Planning Application Ref: FG/162/17/PL {2} Current comments in red typeface

Location: 1 Upper West Drive, Ferring

Description of works: Demolition of existing detached garage & erection of 1 No dwelling

PROPOSED GROUND FLOOR PLAN 1:100

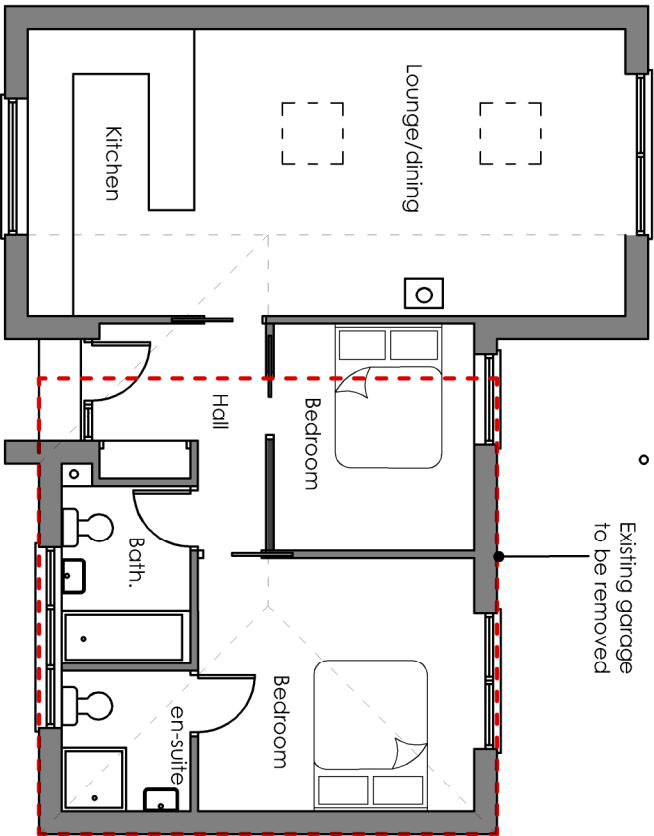
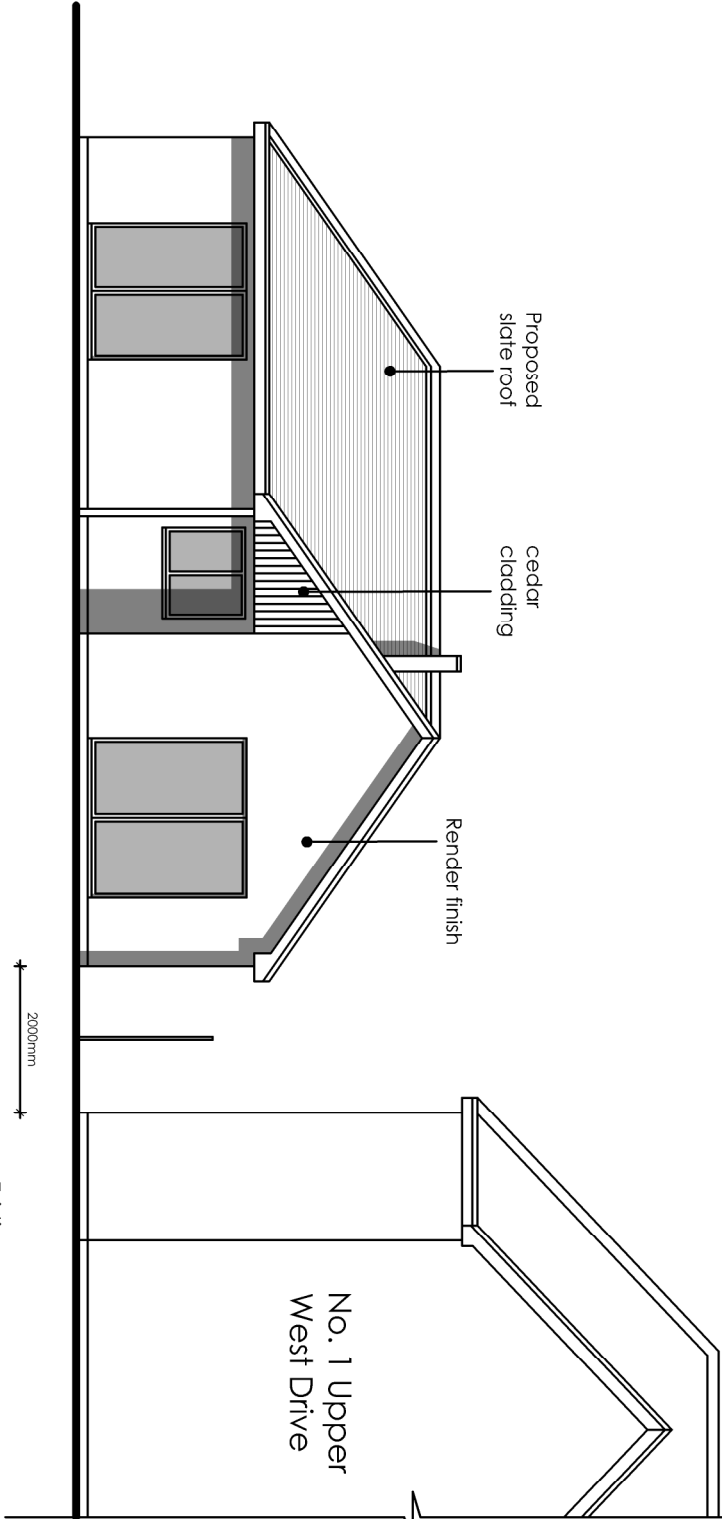
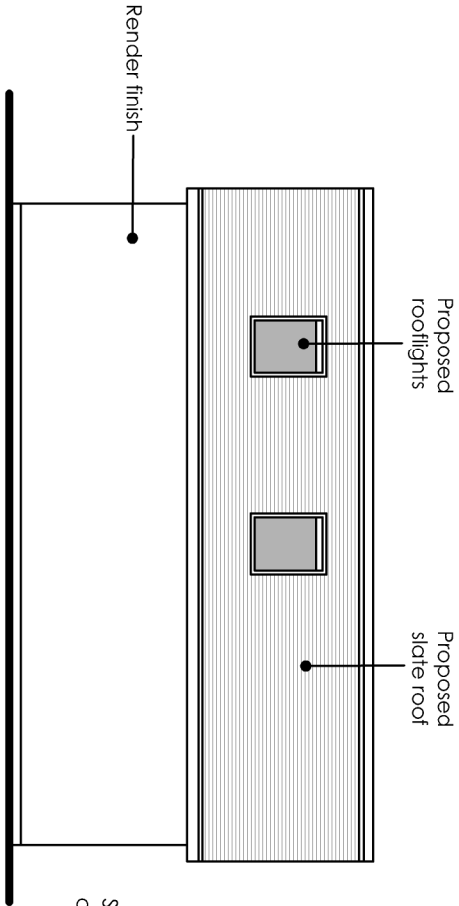
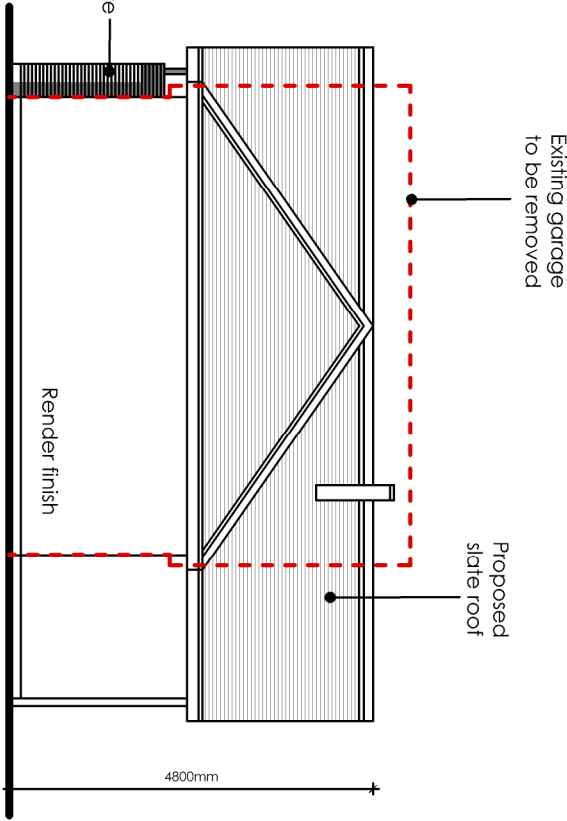
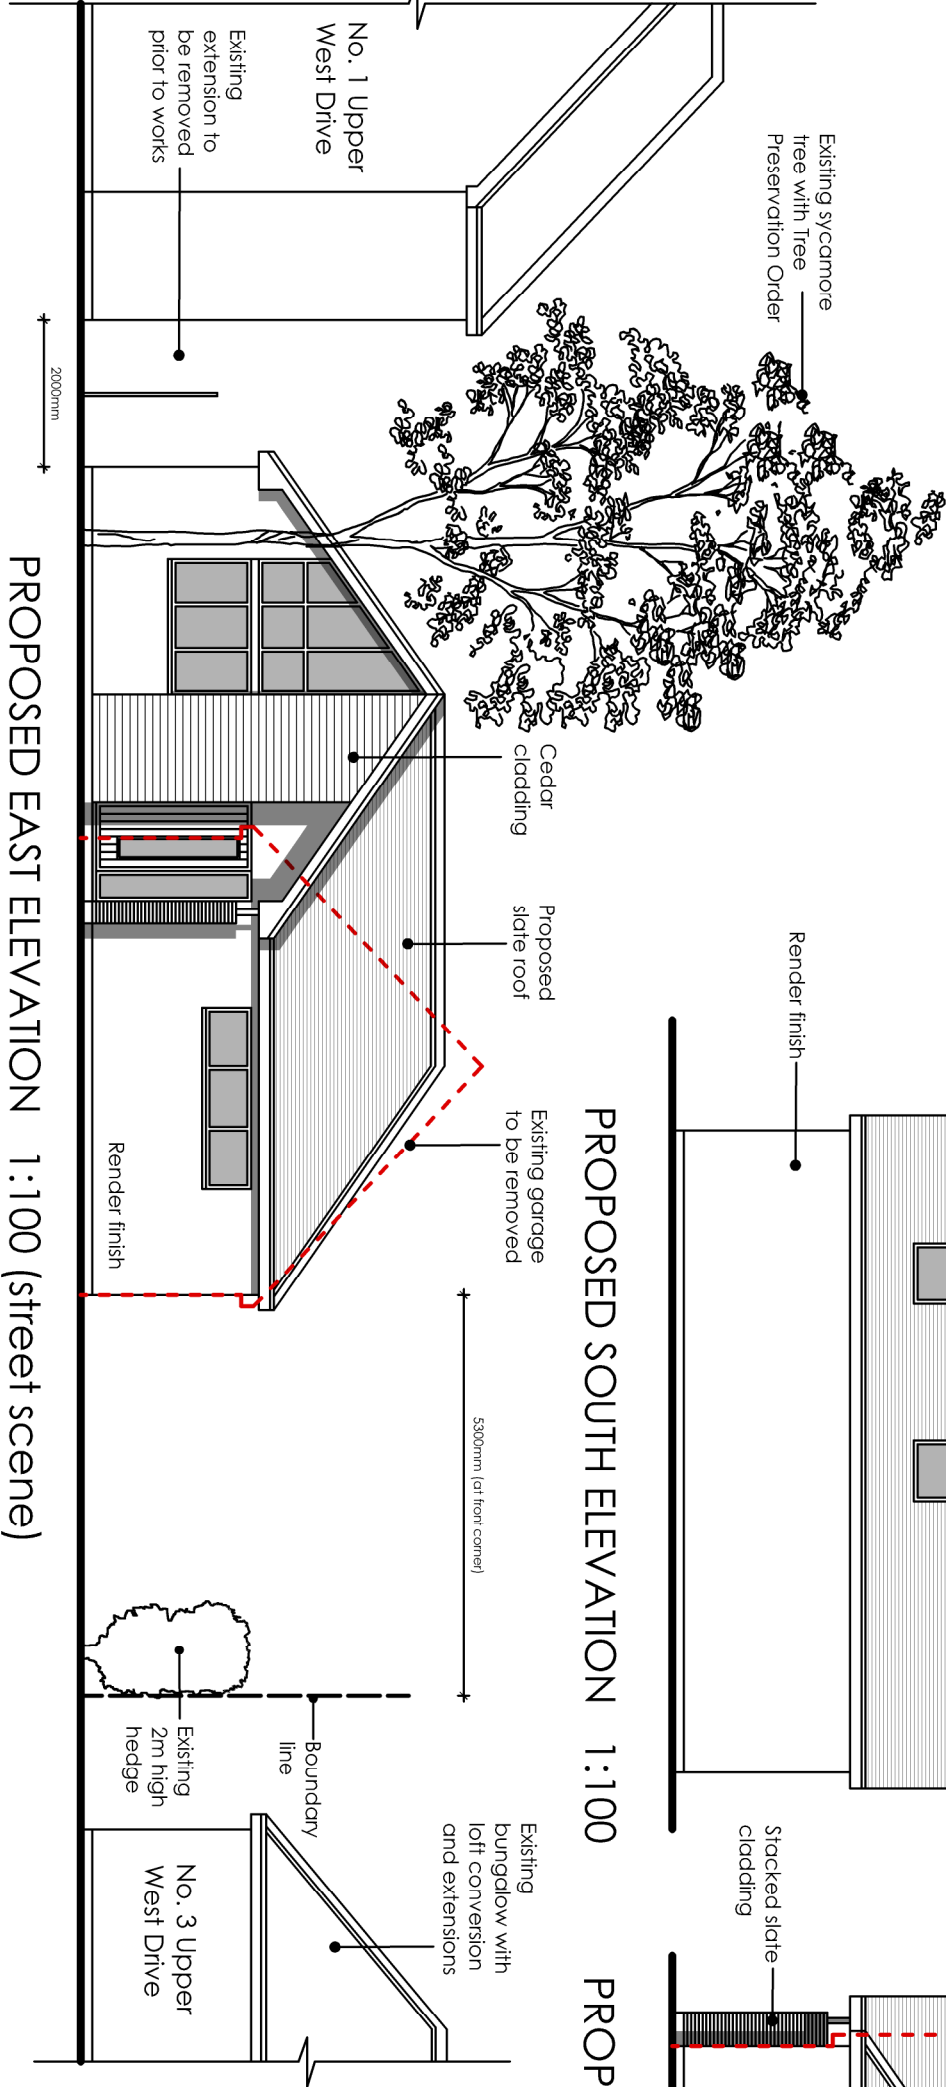
- The footprint of the new building will be well within the Root Protection Area of this tree and will therefore require to be justified and the impacts of any root damage mitigated.

- Pile & Beam foundations might well prove to be a way of minimising the impact of development on tree roots BUT I see no evidence of cross section drawings having been submitted to show the existing and proposed levels to prove that this technique is suitable here and that a 'NO Dig' solution can be applied with an above ground formed pile cap and supporting ground beams.

- There is also the issue of having a new building within close proximity to the crown of a large mature tree where light restriction to habitable rooms is bound to be a factor. It is highly likely that there would be 'pressure to prune or fell' if this layout were approved.

1 Upper West Drive, Ferring
Tree Protection Plan

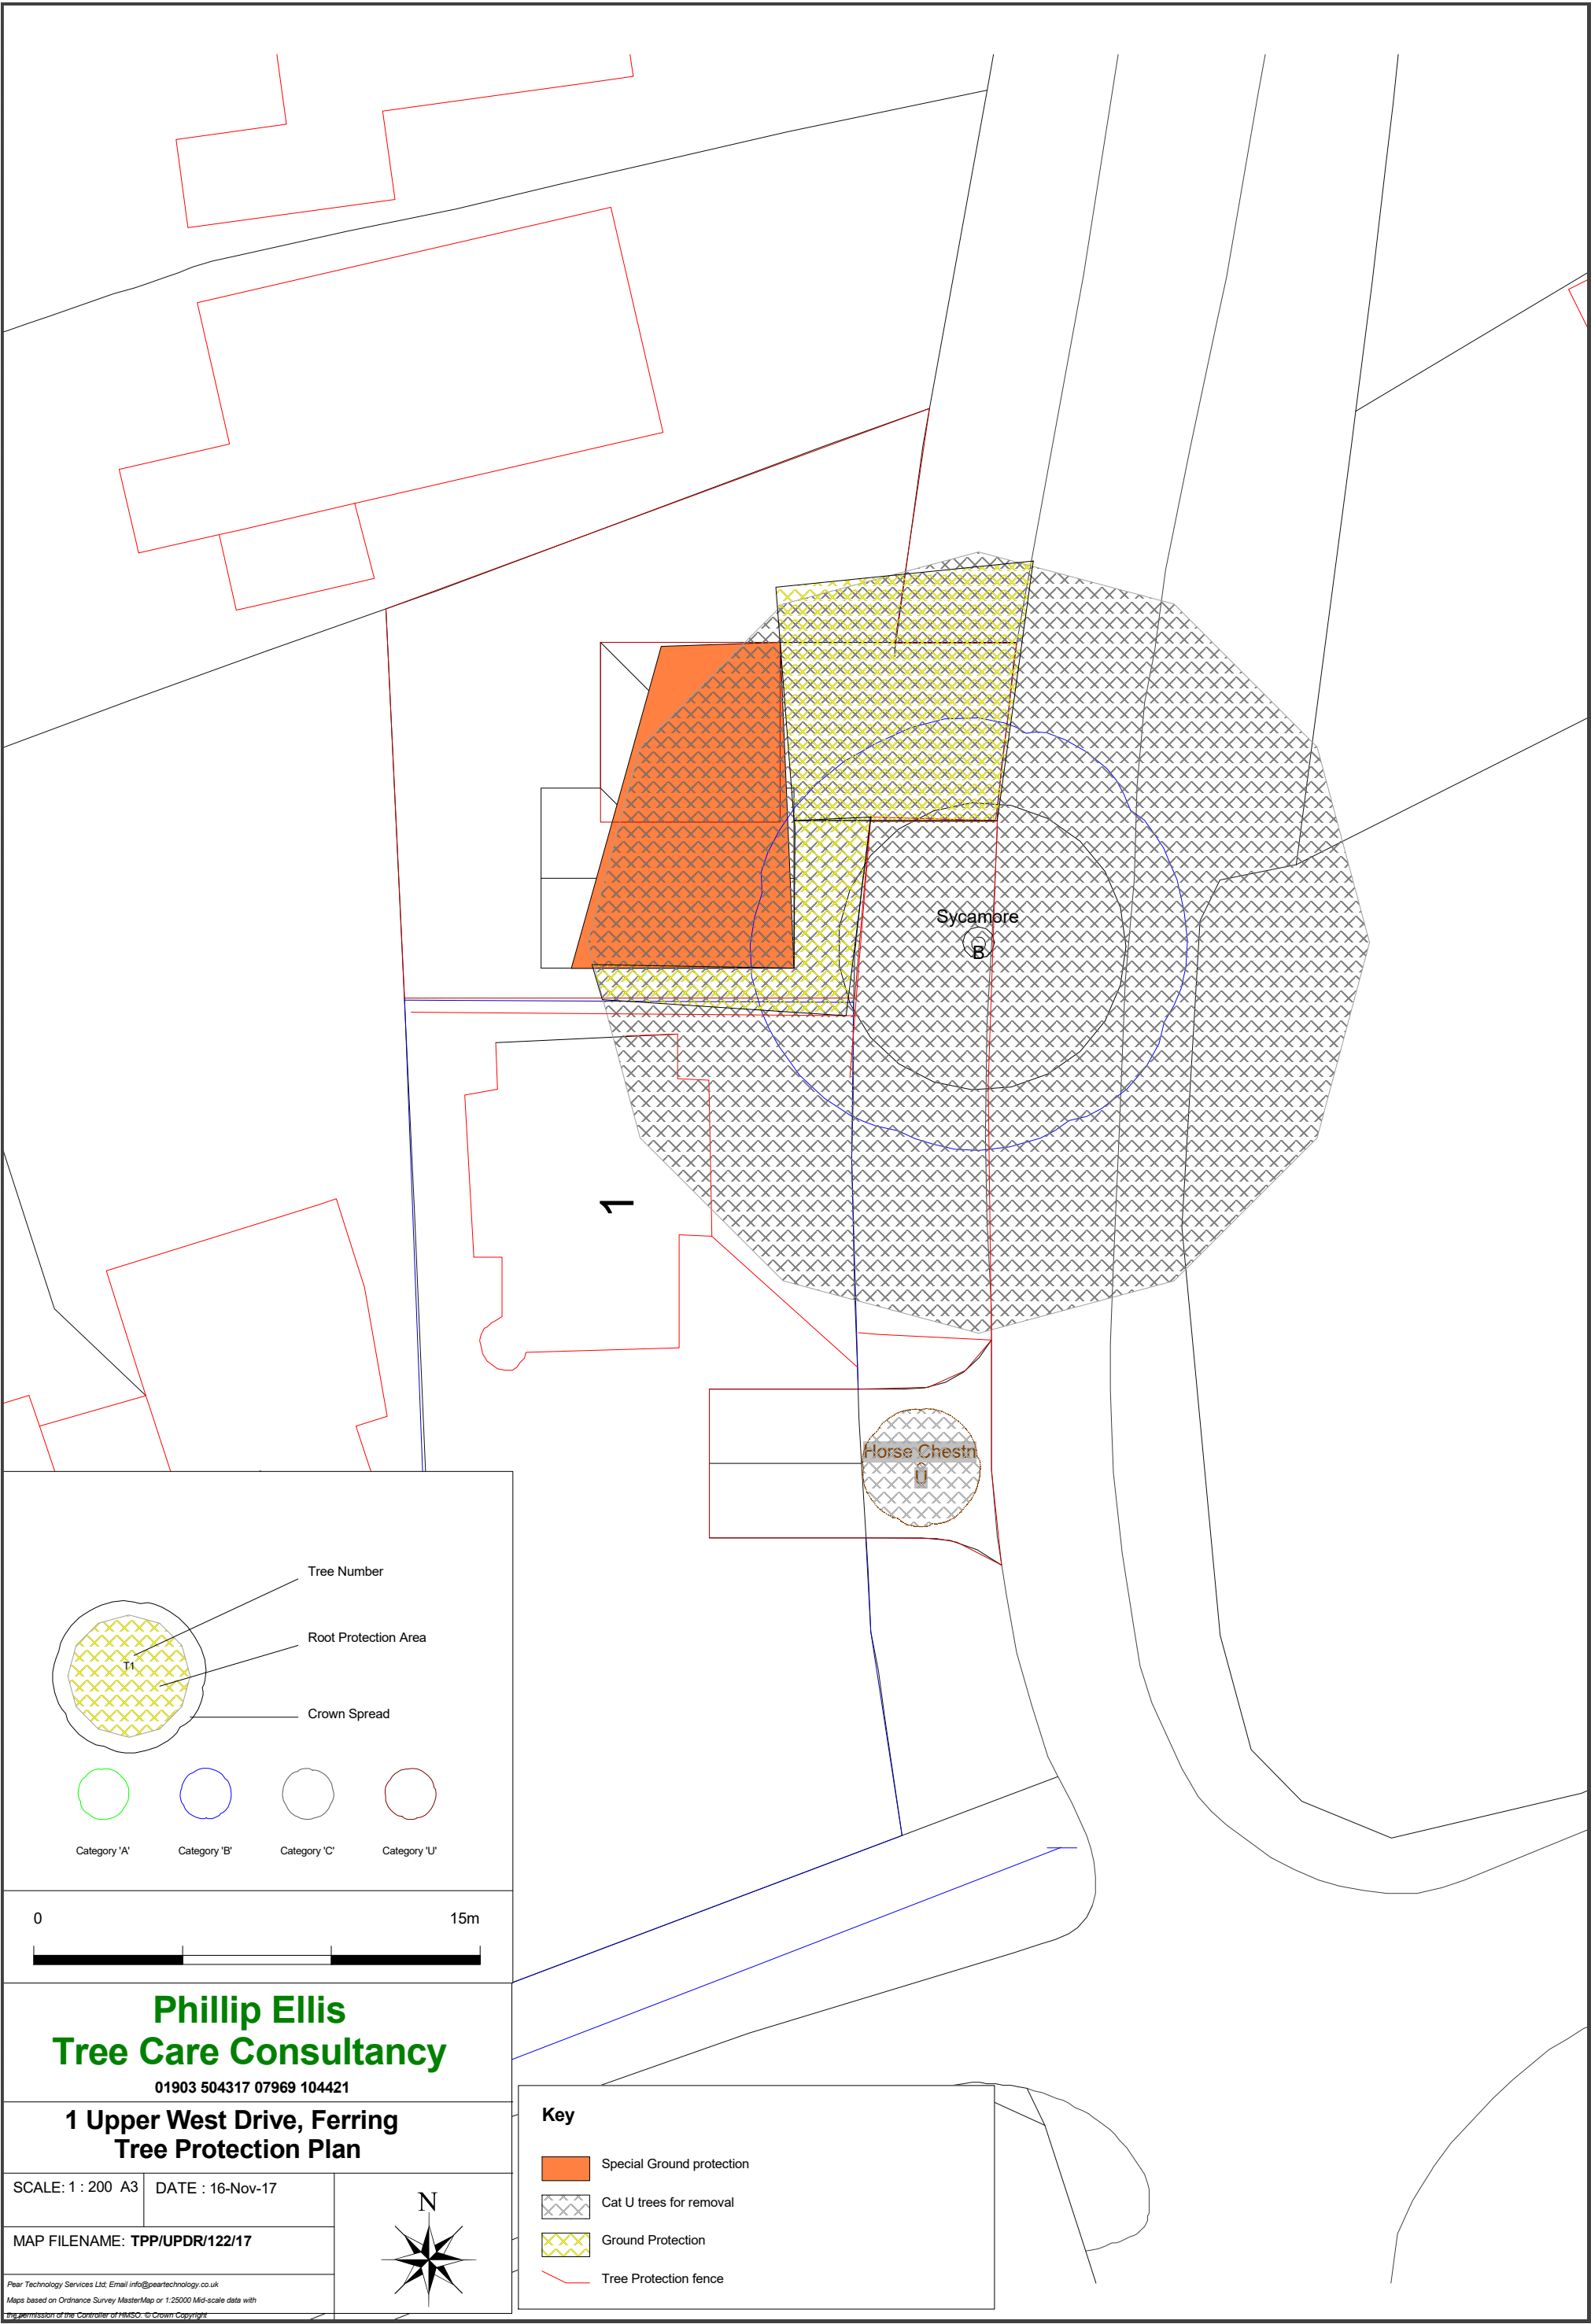
- At 6.1 it says undertake pruning works if recommended -- I see nowhere that it states that pruning is required and yet the plan clearly shows the branches overhanging the footprint of the existing garage and the new building that is proposed. How are they going to erect scaffolding and construct this building without pruning back the canopy. This brings into play another factor in that no sunlight and shading data has been provided and no mention made of same in the report and yet the tree will be hard up against the building line on the east side of same? This brings into play yet another issue for me in that if this tree has to be pruned to even build the property let alone keep it clear of same in the future then this is 'pressure to prune or fell' and confirms my fears in this respect.

- The applicants Architects report has acknowledged that the RPA overlaps the footprint of the new build but has simply said that a 'suitable foundation system will minimise the damage to the existing root system'.
- However, one key element is missing in that the protective fencing is shown to be hard up against the new building and in this position it would hinder the construction process.
- The submitted report does not give me any confidence that this building can be constructed without significant damage to the root system and future 'pressure to prune or fell' due to its close proximity.
